**Our ref:** AN/2023/135033/01-L01  
**Your ref:** EN070008  
**Date:** 11 January 2023

**Application by Chrysaor Production (UK) Limited for a Development Consent Order (“DCO”) for a 55km underground pipeline for the transport of Carbon Dioxide from the Immingham industrial area to offshore storage – the Viking CCS Pipeline (“the Proposed Development”)**

- 2.2 We have reviewed the Development Consent Order (DCO) application, Environmental Statement (ES) and supporting documents submitted as part of the above-mentioned application, following notification of its acceptance for Examination on 22 November 2023. Our comments below are presented using the document references and ES Chapter headings relevant to our remit.

LEGEND

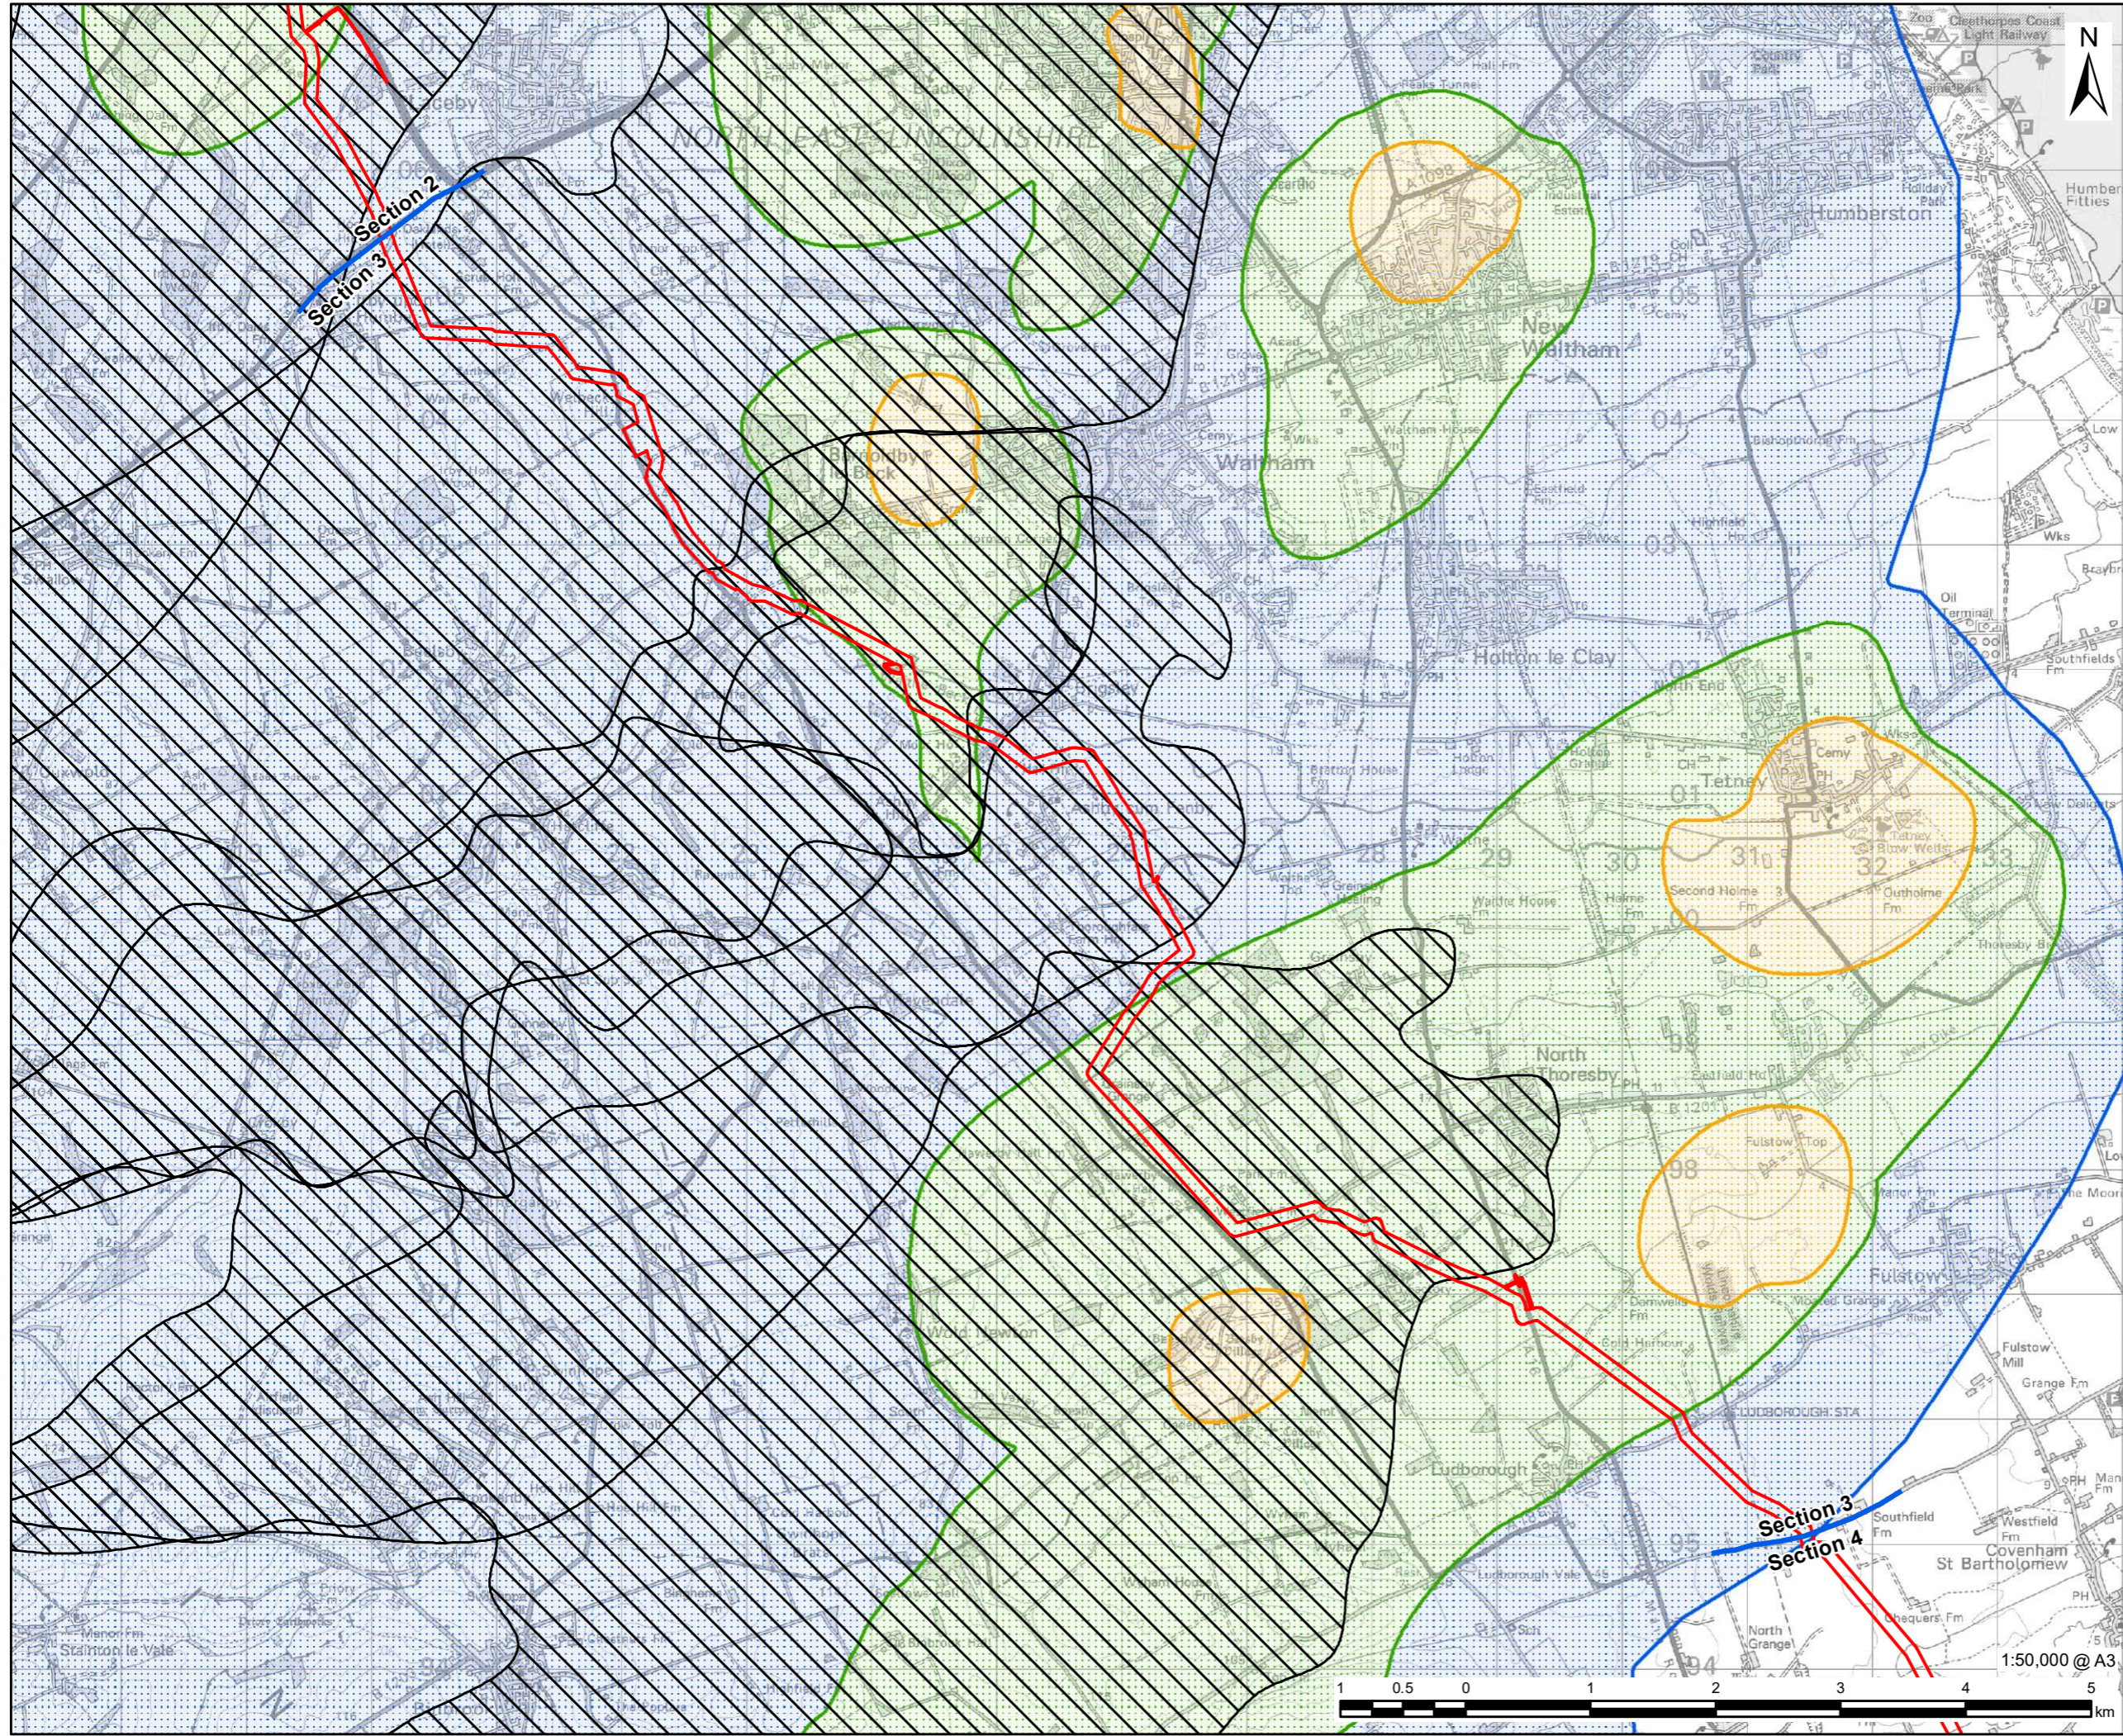
- 6.5 Section 1.3.2 states that groundwater safeguard zones are meant to be designated in Figures 1.2 and 1.3; these are not evident on the diagrams.
- 6.6 We note that in the absence of site-specific ground investigation data at this stage, the Hydrogeological Risk Assessment (HyRA) is considered to be 'preliminary' and will be reviewed and updated based on the findings of future ground investigations. We would like to be consulted on any future updates and believe this is secured through mitigation measure E3 in the draft CEMP (subject to our request to be a specific consultee to the final CEMP discharge).
